**Project Name:** \* Bridge 9 over South River on US 13

Subject: **Request for Additional Information for T.I.P. B-4635 (Replacement of Bridge 9 over South River Overflow on US 13, Sampson County)**

Below are responses to needed additional information and corrections to previously submitted items for the permit application for B-4635 (Replacement of Bridge 9 over South River Overflow on US 13, Sampson County)

**PERMIT DRAWING
SHEET 3 OF 18**

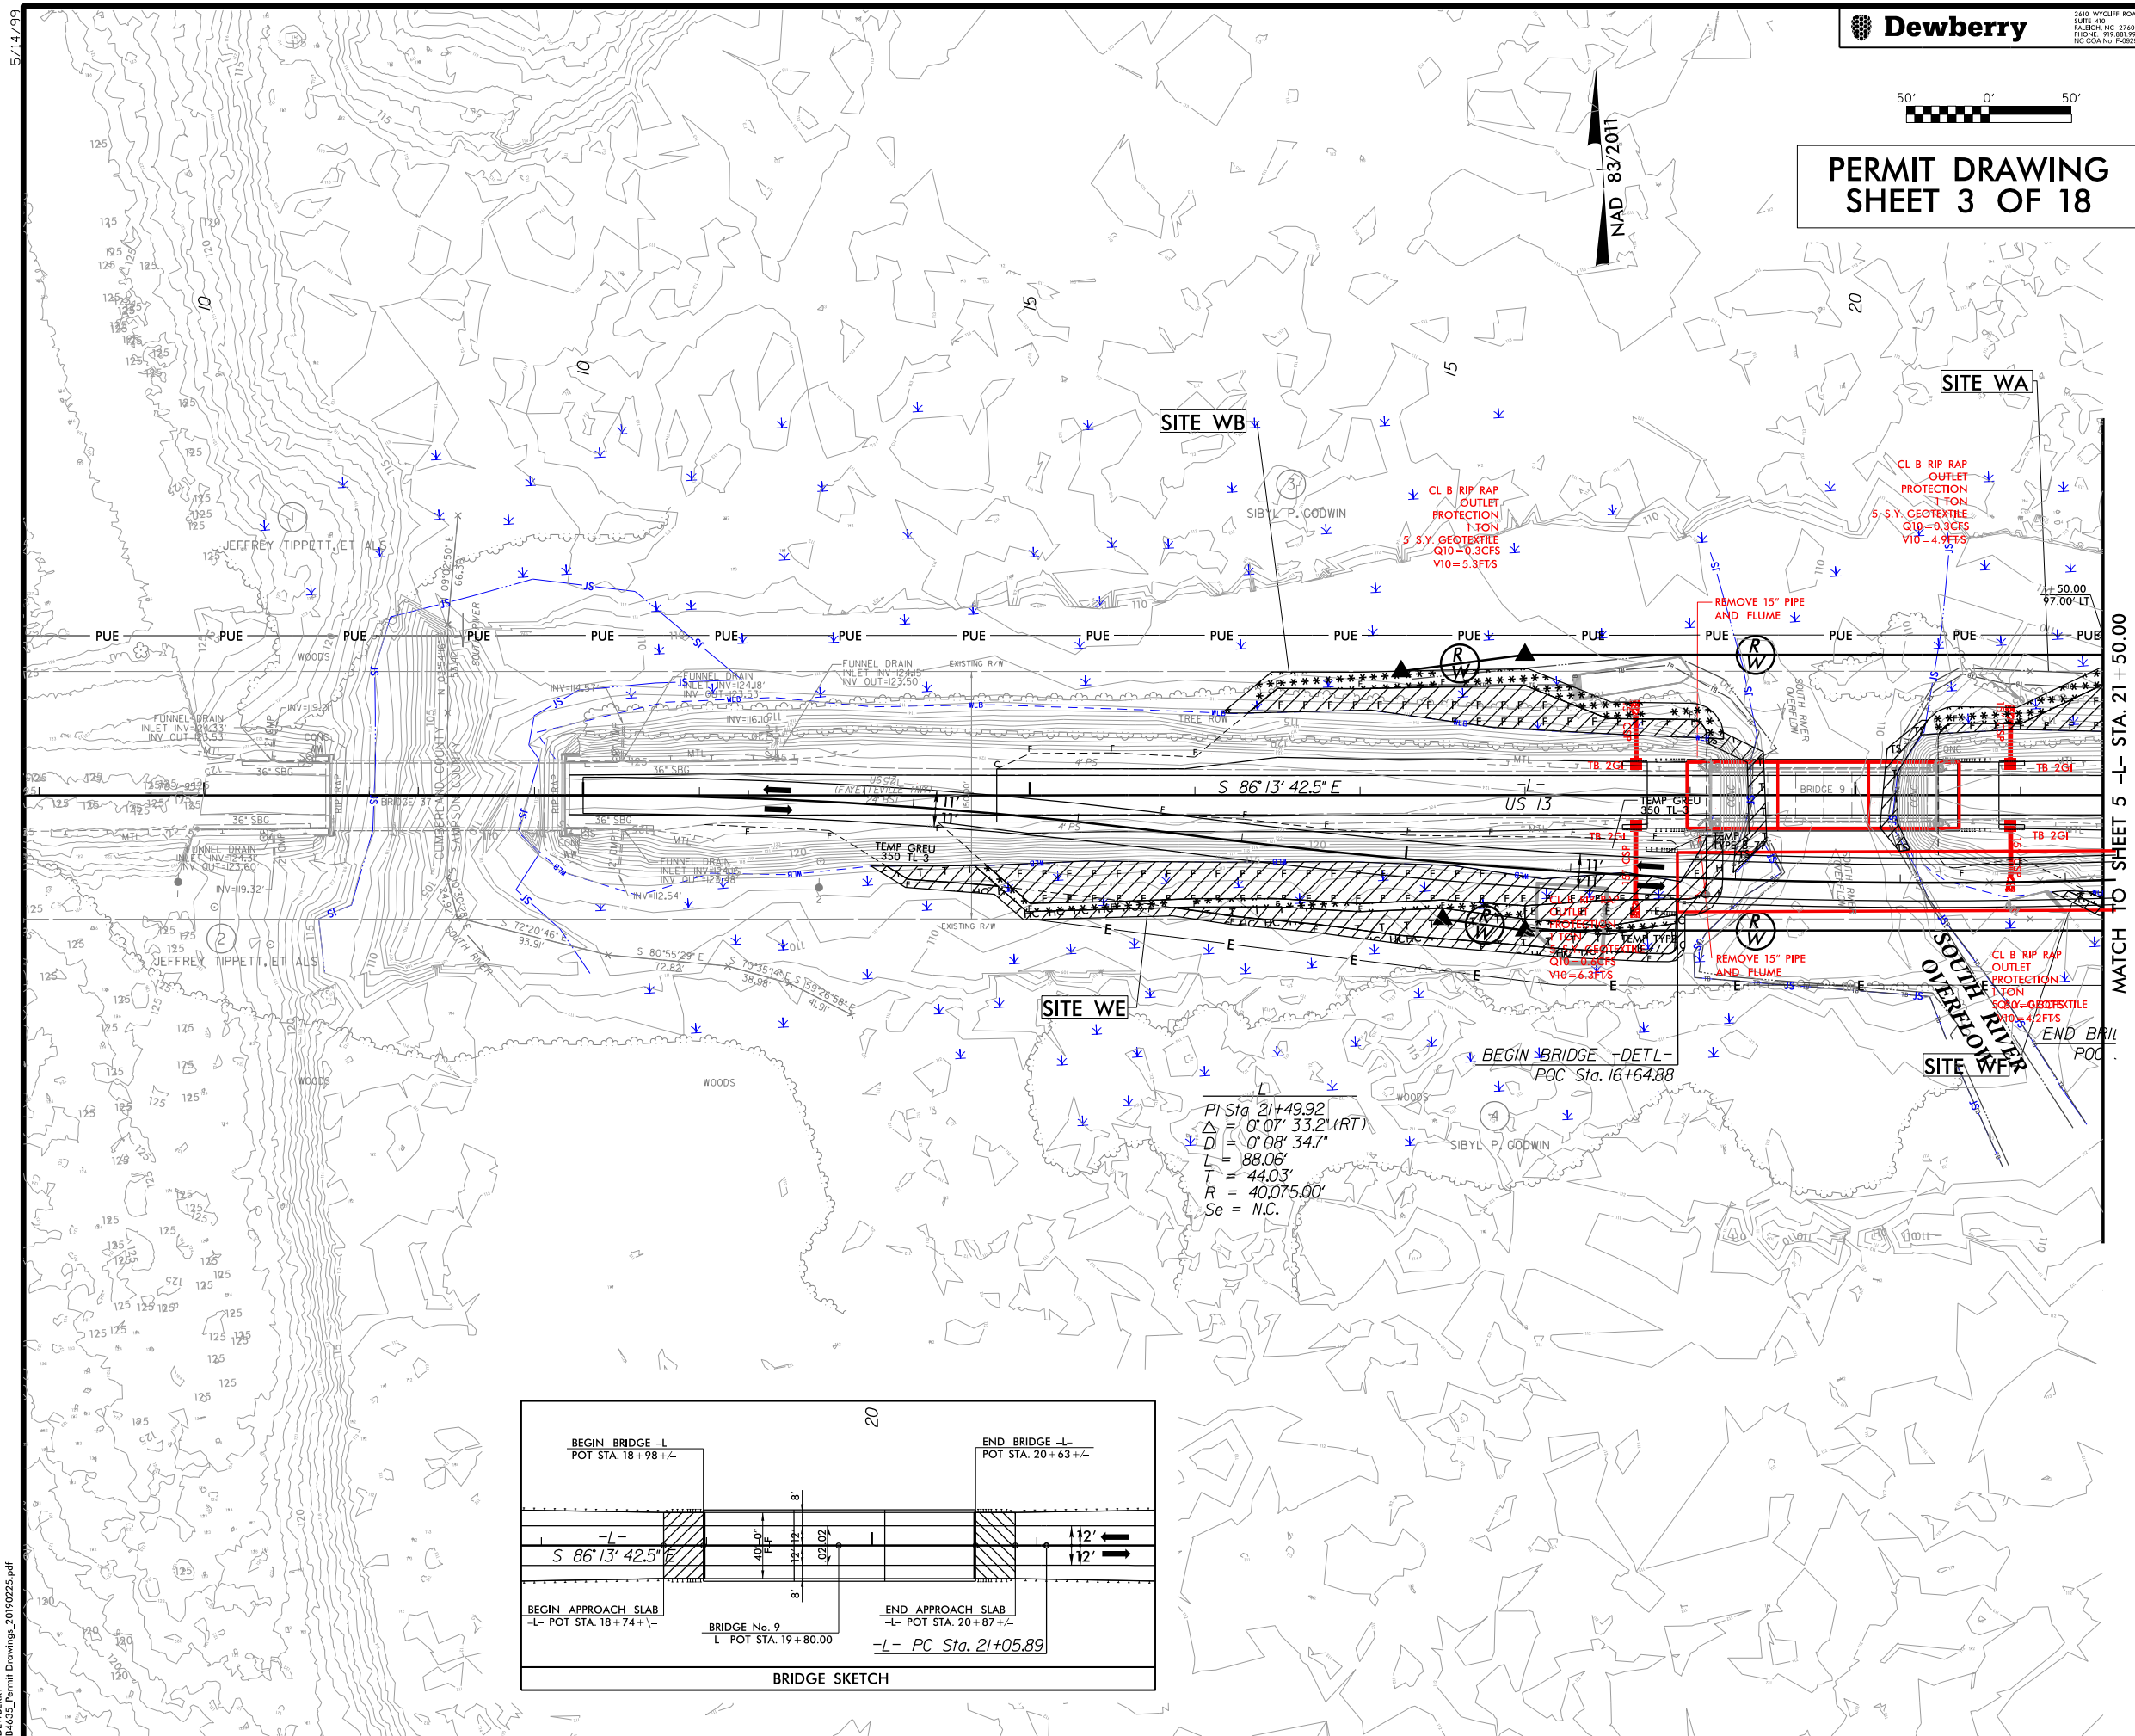
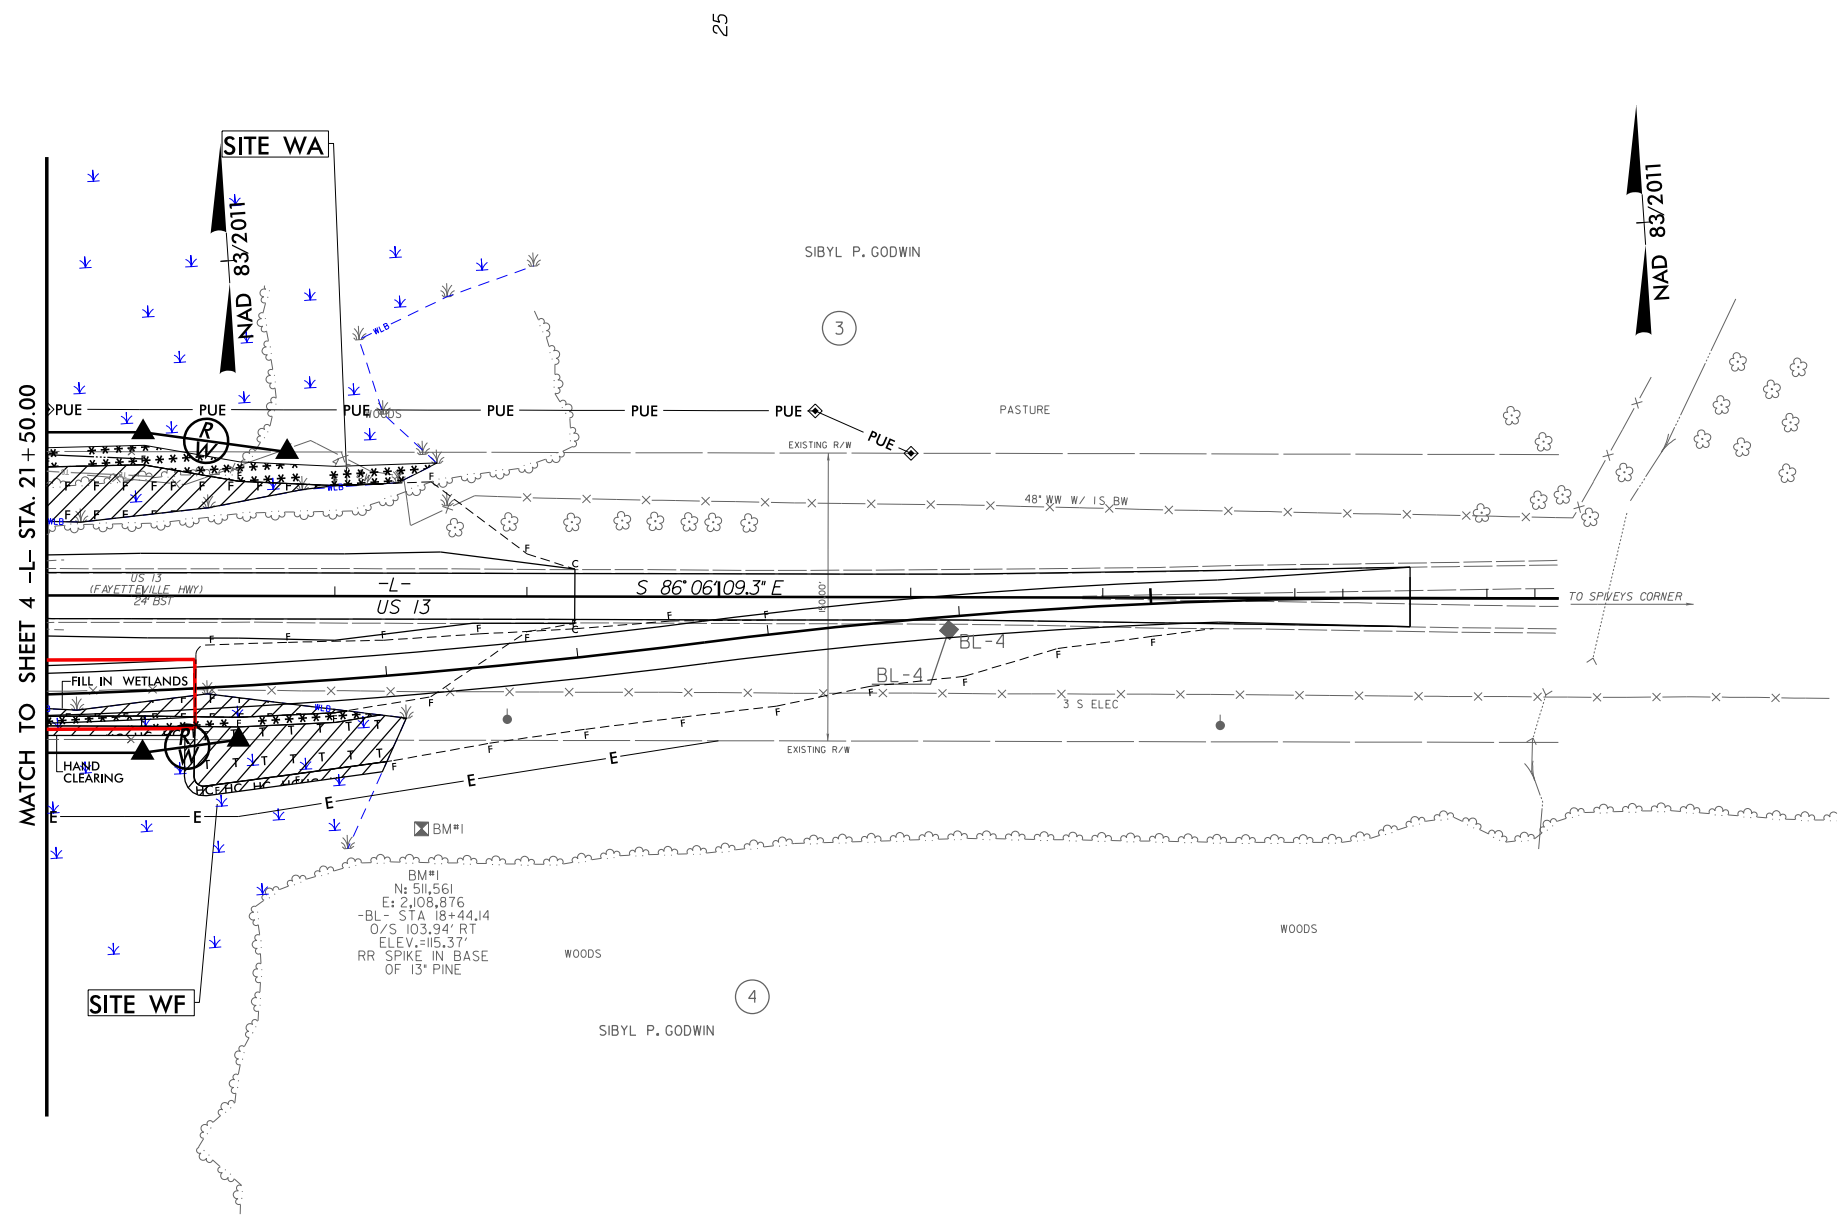
- along the north side of the project where permanent fill is called for HC is noted. Within Division 3, MC has always been requested along the slopes of permanent fill. This has been confirmed with Division please correct throughout the package. If less than 10' of fill 5' of MC is appropriate and greater than a 10' fill height 10' has been the standard. **Permit drawings have been revised.**
